**PROPOSED CONNAH'S QUAY LOW CARBON POWER PROJECT**

**PLANNING INSPECTORATE REFERENCE: EN01066**

**RE: NATURAL RESOURCES WALES' WRITTEN SUBMISSION FOR DEADLINE 2**

Surface Water Features
Sheet 1 of 3: Key Plan

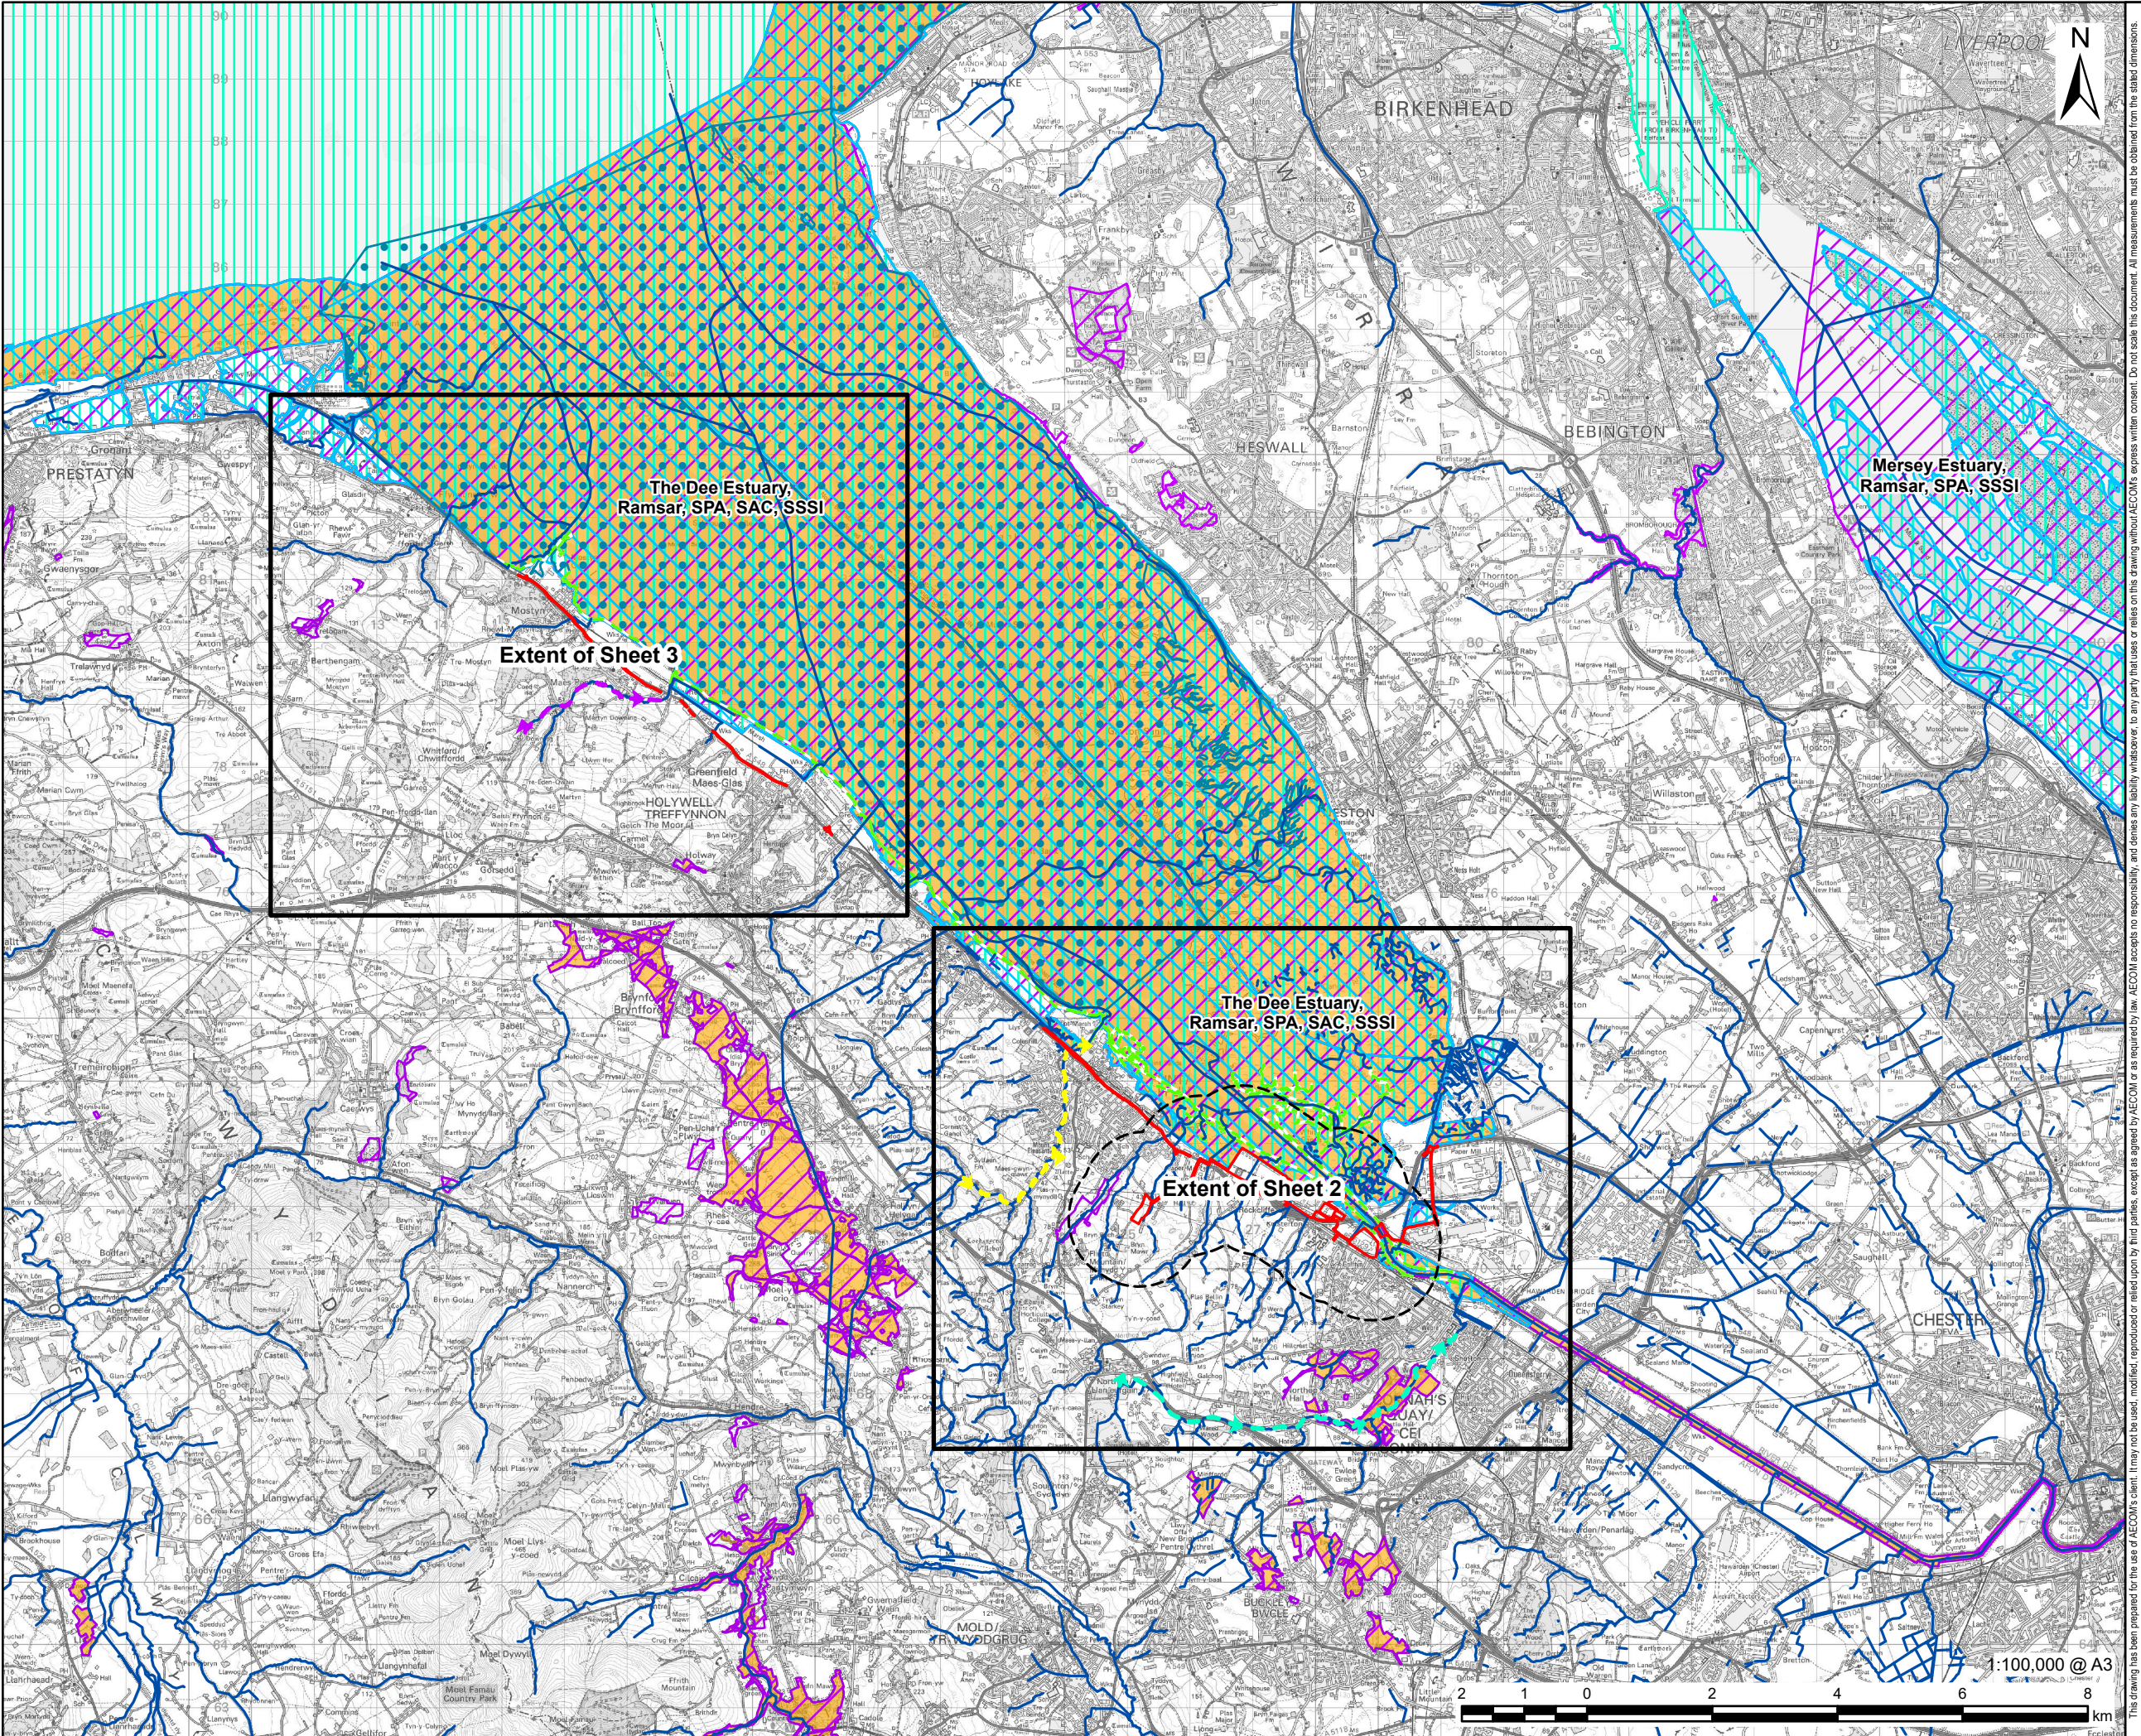
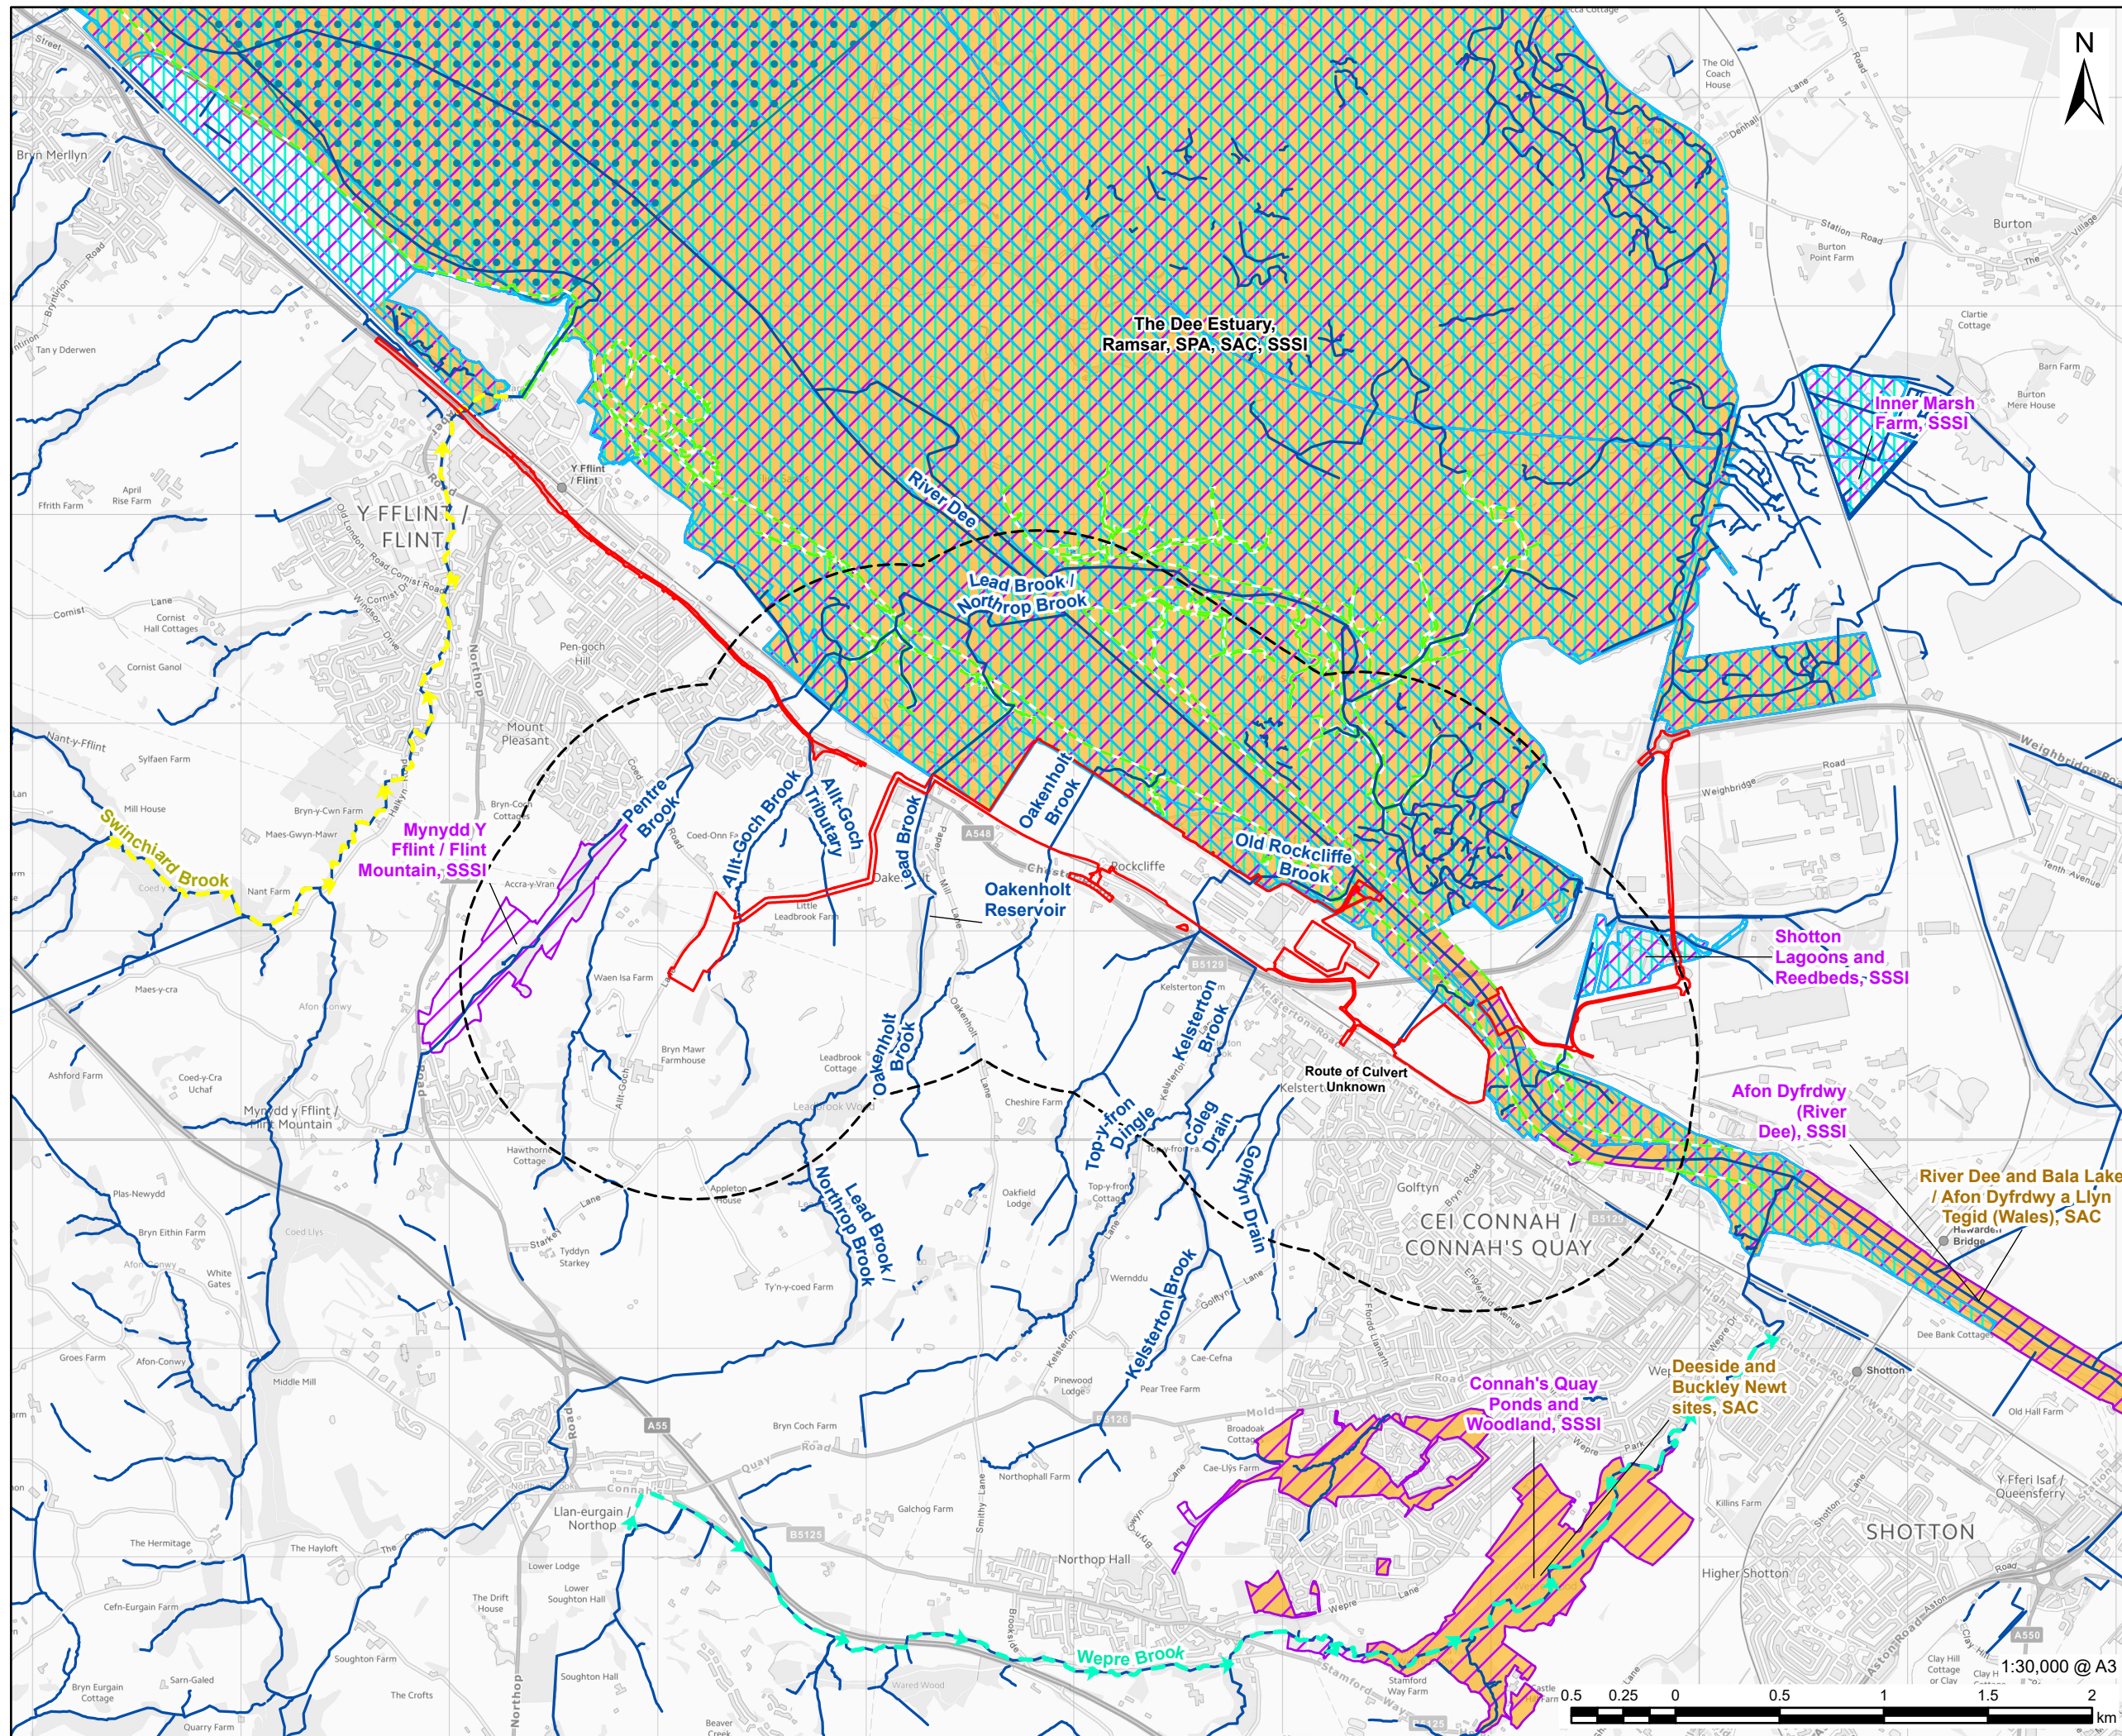
We note and welcome that Figure 13-1 has been updated to include the screened-out Water Framework Directive water bodies, namely Wepre Brook and Nant Sir Roger (Dee Estuary). We therefore have no further concerns regarding this matter.
